July 12, 2022

**Re: Slim Chickens**  
**8240 Montgomery Blvd. NE**  
**Traffic Circulation Layout**  
Engineer's Stamp 07-5-2022 (G19-D004E)

Re: **SLIM CHICKEN-ALBUQUERQUE  
8240 MONTGOMERY BLVD.NE  
TRAFFIC CIRCULATION LAYOUT  
ENGINEER'S STAMP 05-18-2022 (G19-D004E)**

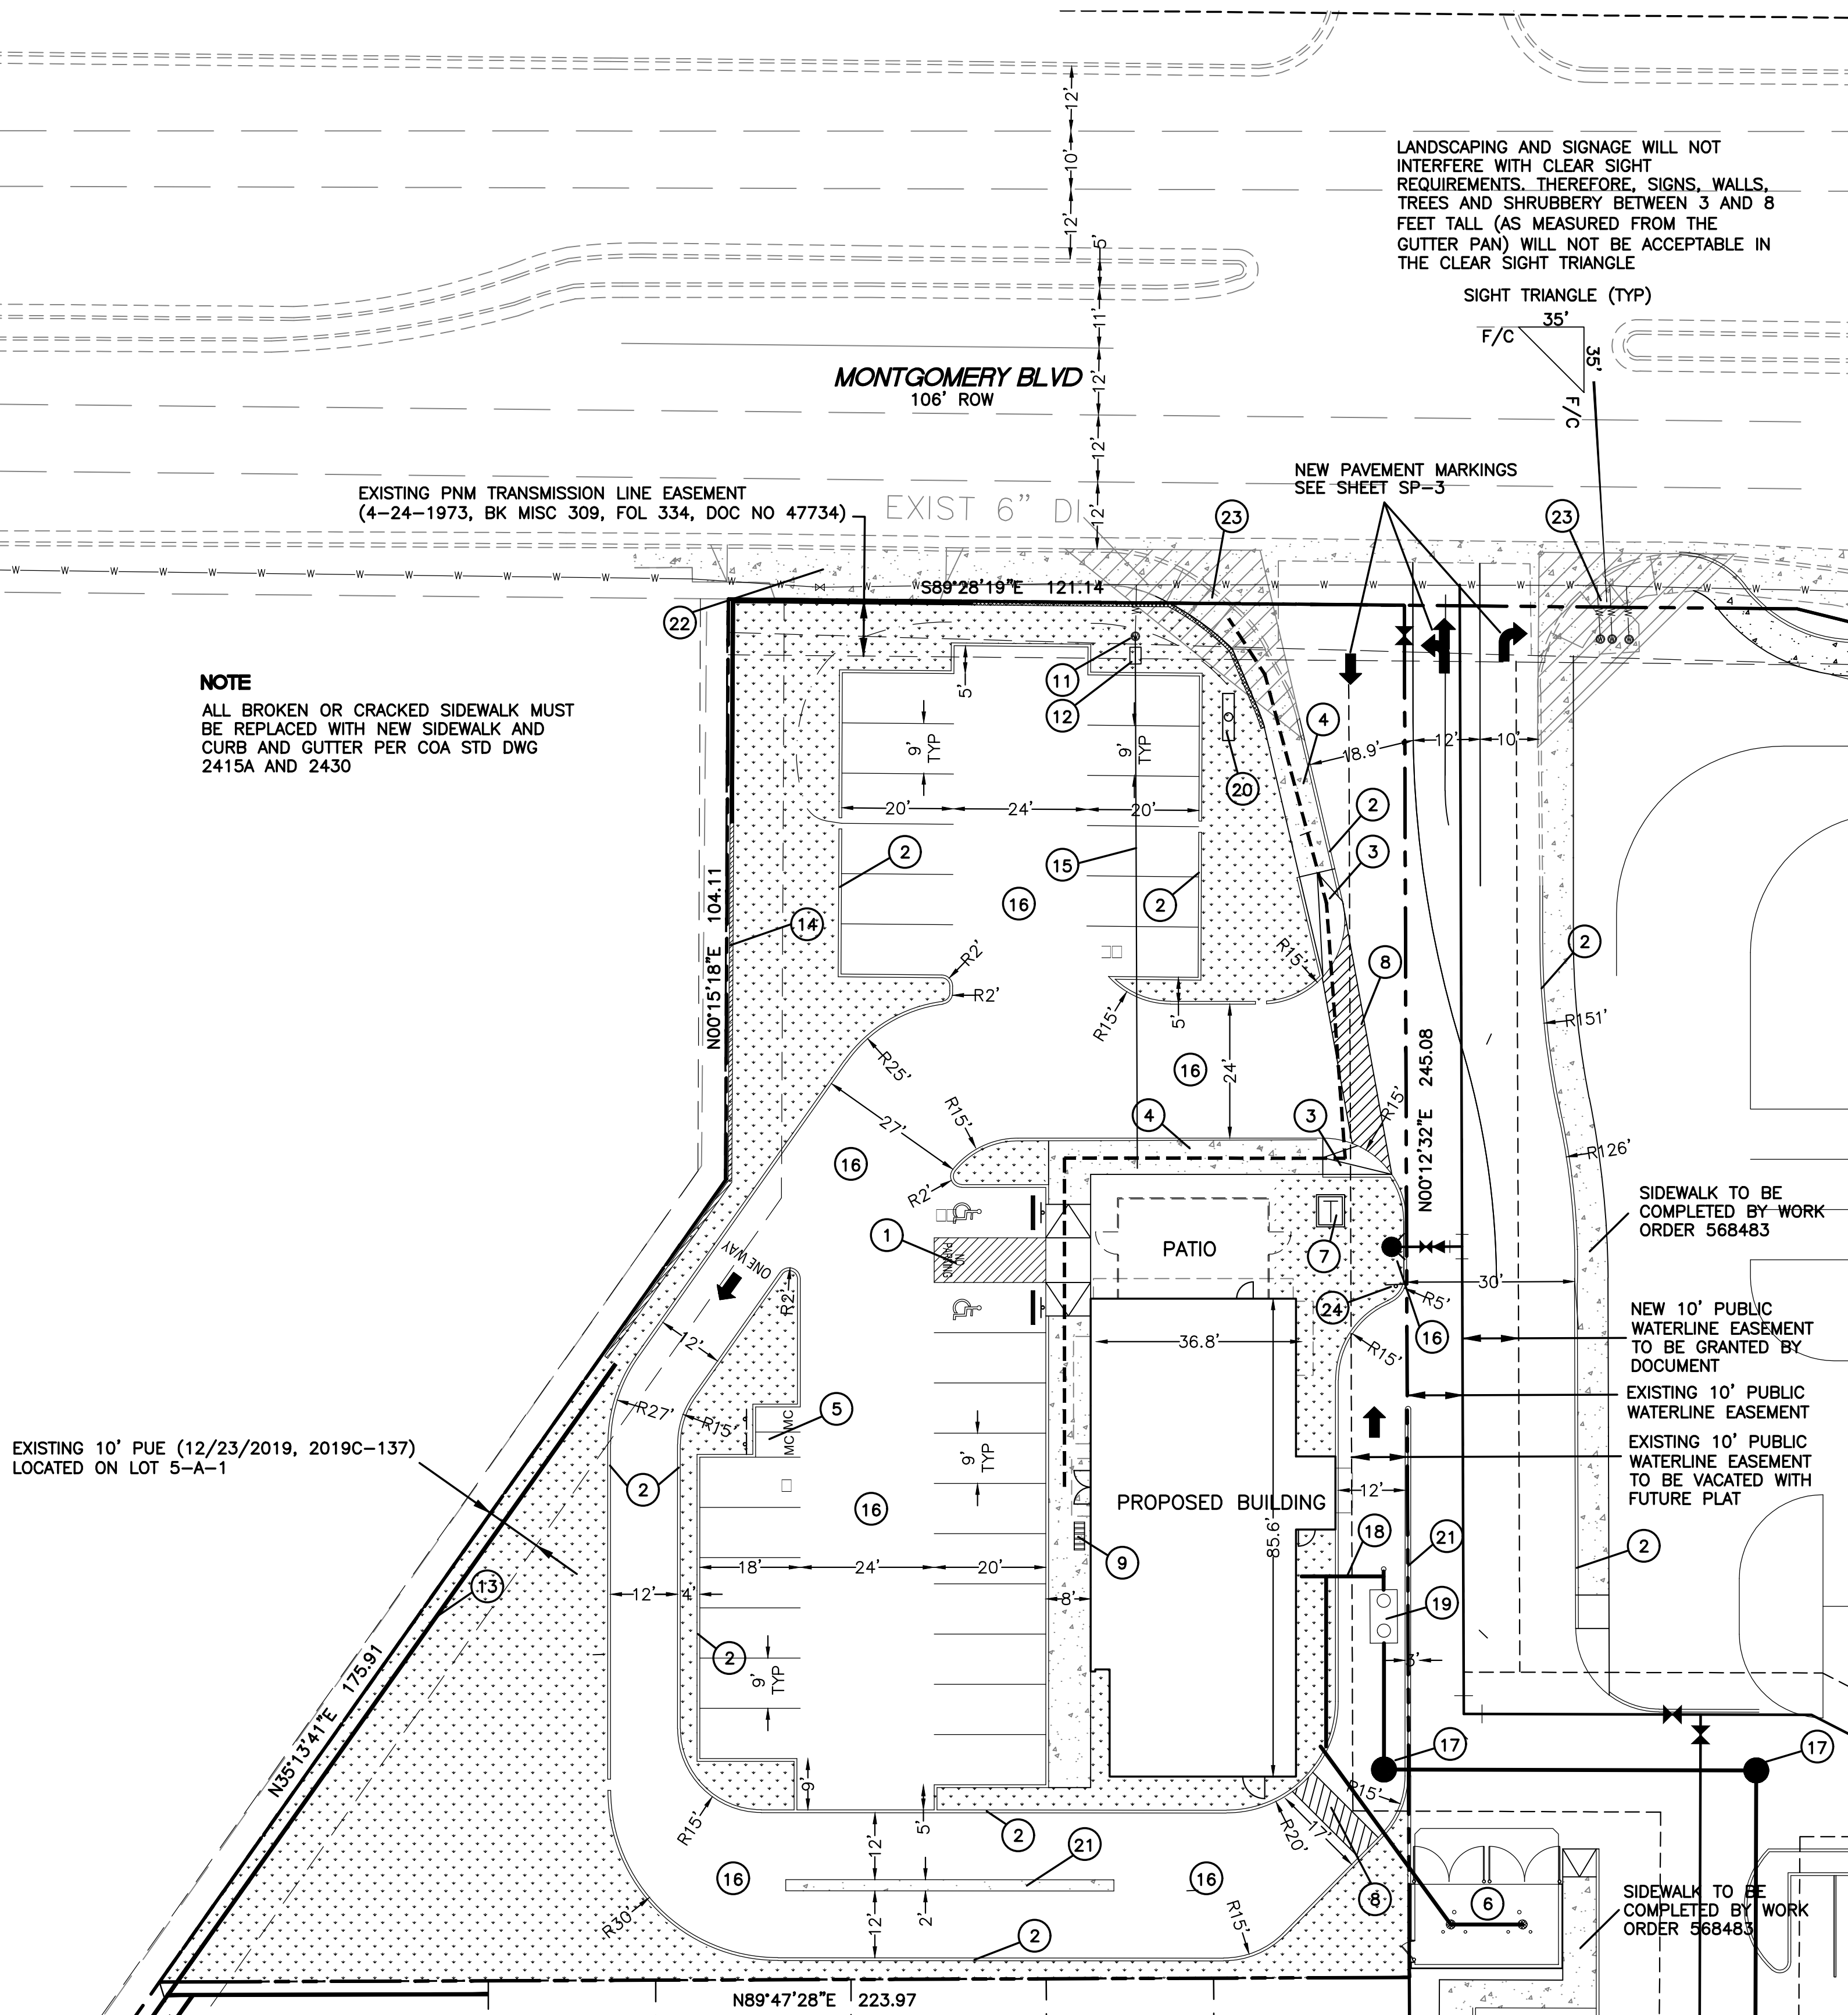
- Suggestion: redesign the main entrance per COA std dwg. 2426 to provide a 6' valley gutter with 1" invert. Replace the existing 4' valley gutter with 6' valley gutter to serve ADA across the entrance.

- The main drive aisle will need striping for ingress/egress vehicles movement. Striping will be needed on the frontage segment of Slim Chicken.  
**We are showing new striping as requested.**

- Provide striping and arrows for the 24' proposed entrance.  
**We are showing new striping as requested.**

- Drive-thru lane: The exit lane has not throat depth for sight distance (oncoming traffic right vision with oncoming headlights and opposing traffic perception reaction). Please provide one storage length at exit to straighten vehicle for reaction of oncoming vehicles in both directions.

**This was reconfigured as we had discussed on the phone.**
- You will need the following: All one-way drives shall have "One Way" and "Do Not Enter" signage (both sides on exit) and pavement markings. Please show detail and location of posted signs and striping (include Stop Sign and sign face details).

**This information was added to the Site Plan and Detail Sheet.**
- The exit vehicular movement will be dedicated to a left turn movement ONLY. Provide a sign specifying left turn and no right turn out due to the tight radius which cannot accommodate the turn movement

**As we are not modifying the entrance itself and the existing valley gutter is in good condition we believe it best to leave it as is.**

**With the new drive thru configuration we believe this can be a full exit.**

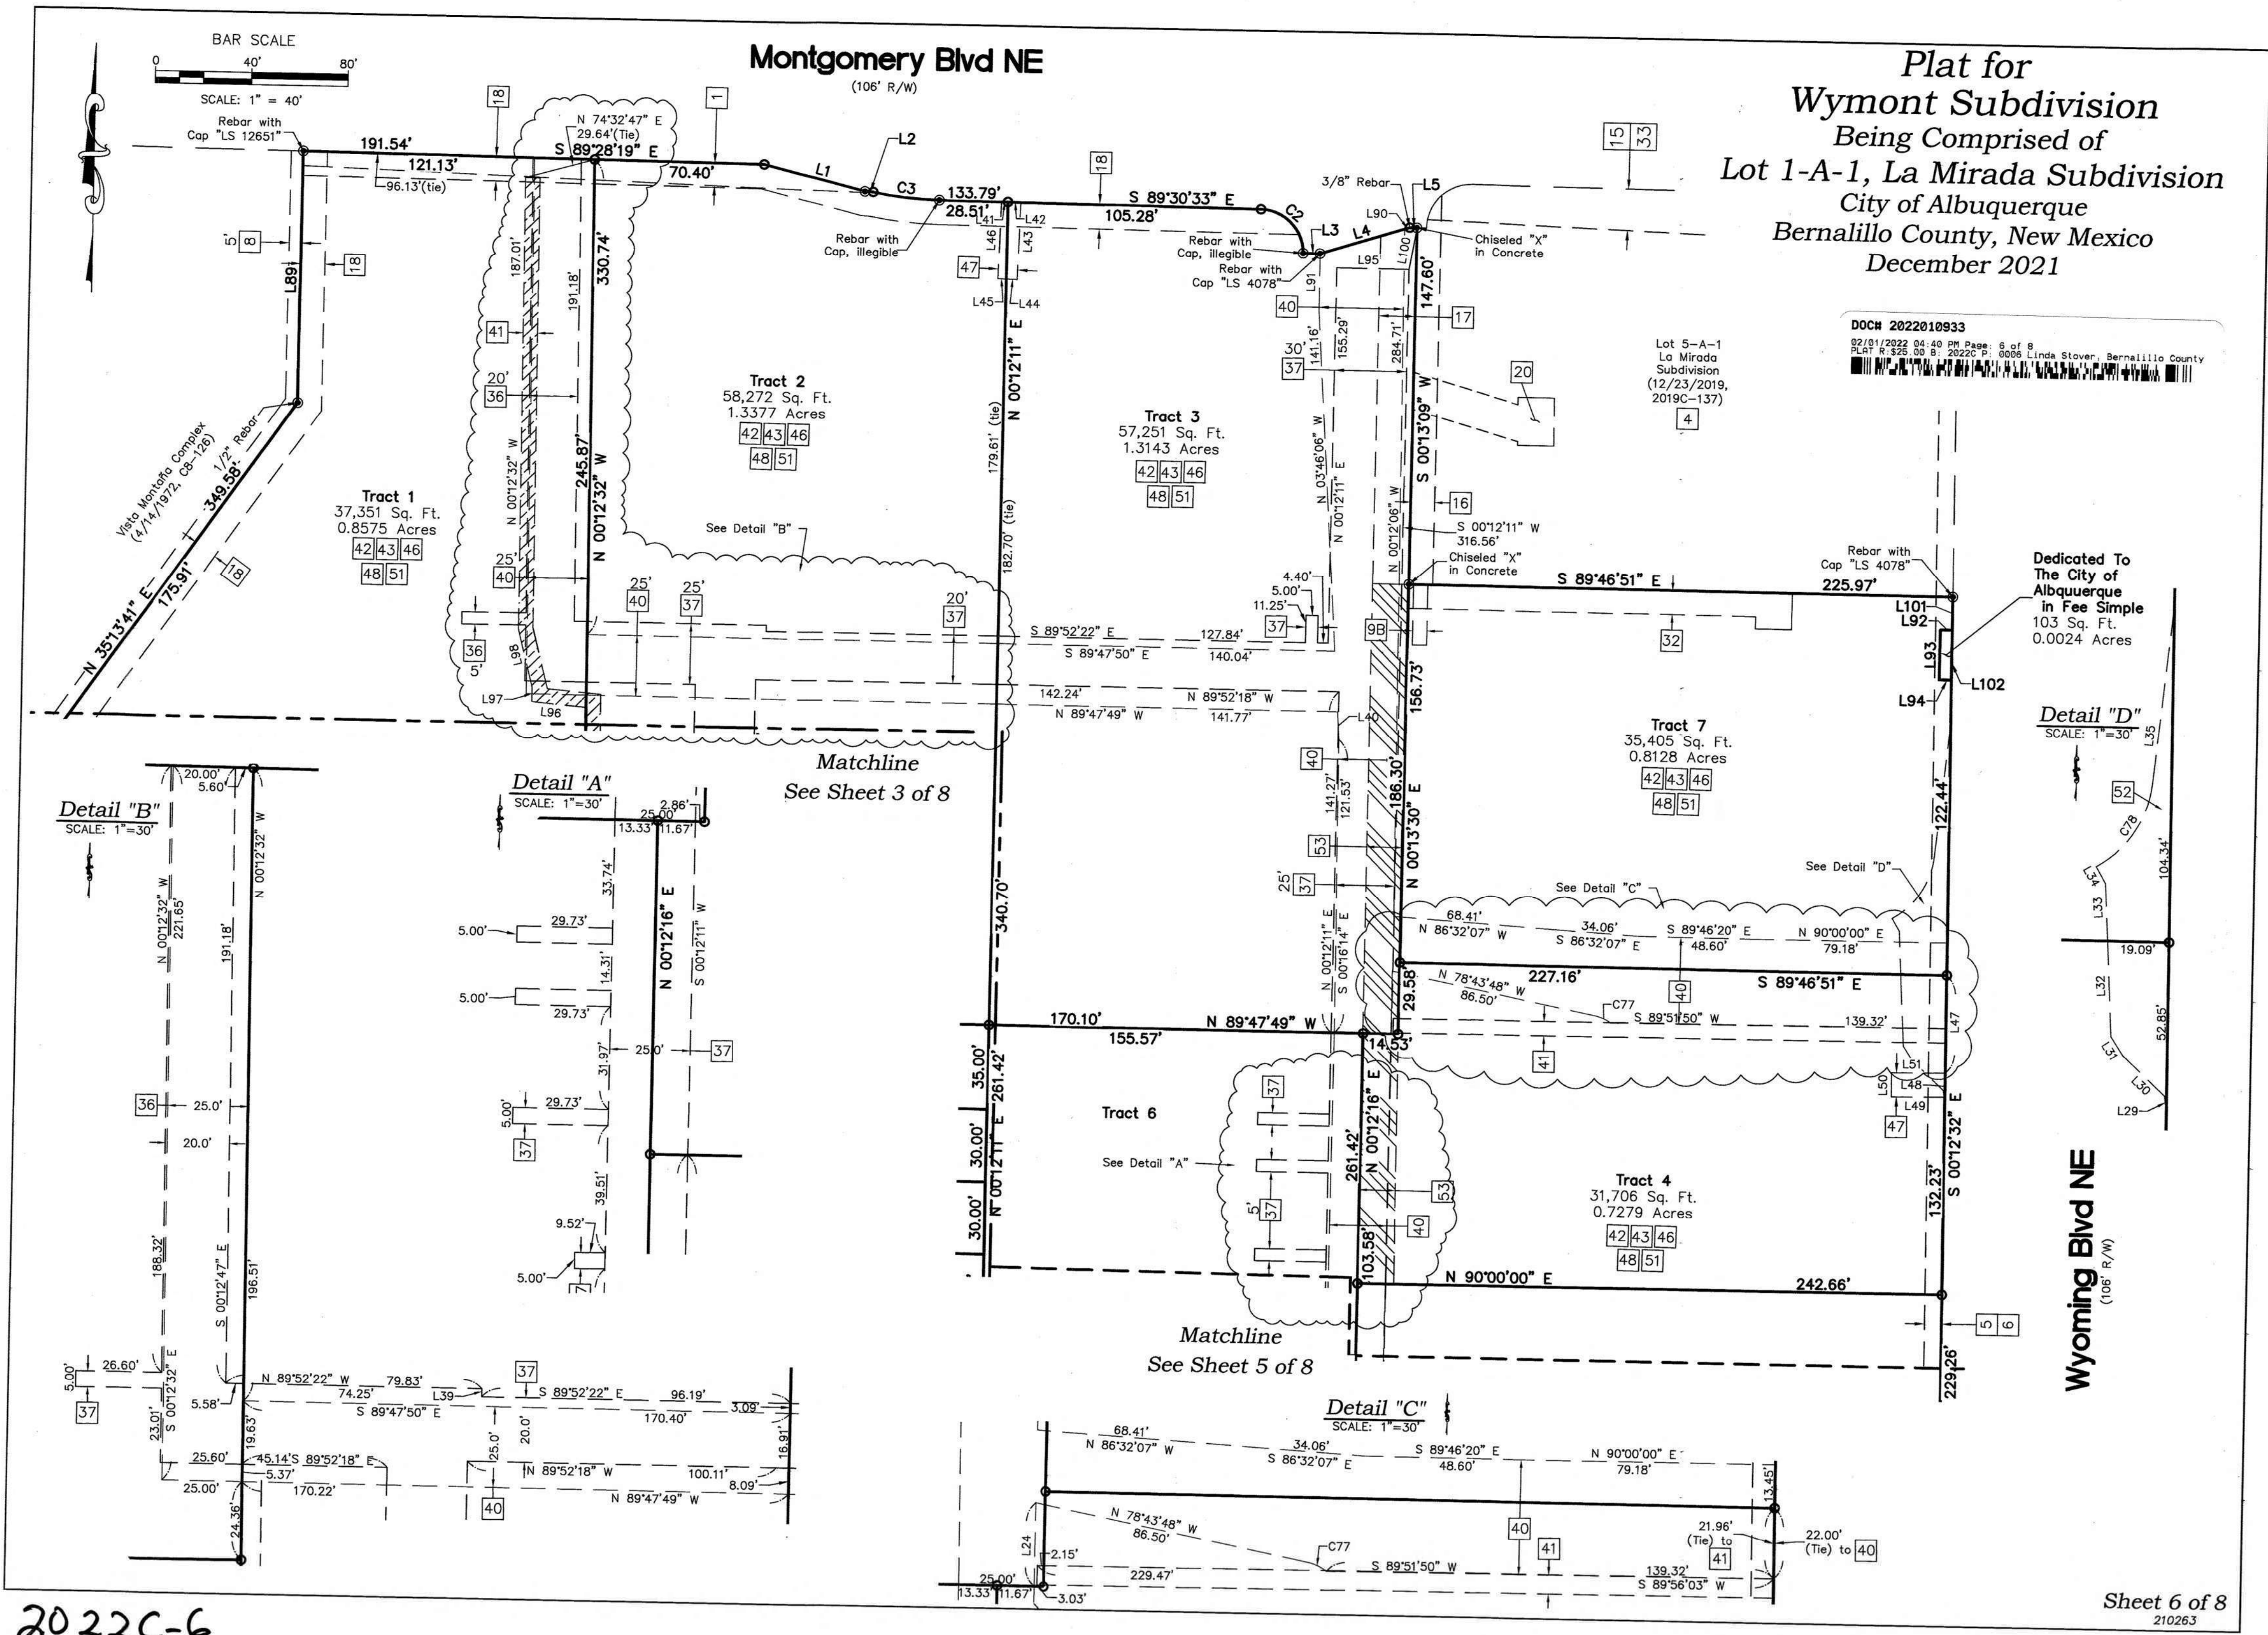
- Plat for Wymont subdivision keynote 40: Private Rodway Easement should serve Tract 1-8. And on sheet 6 the location of driveway easement doesn't match the proposed drive aisle. The easement will need to encompass the proposed drive aisle shown on site plan. Please address this concern.

**We agree with this statement and plan to have the easement adjusted and recorded prior to the building opening for business.**
- Plat for Wymont subdivision keynote 41: Public sidewalk easement doesn't match site plan.
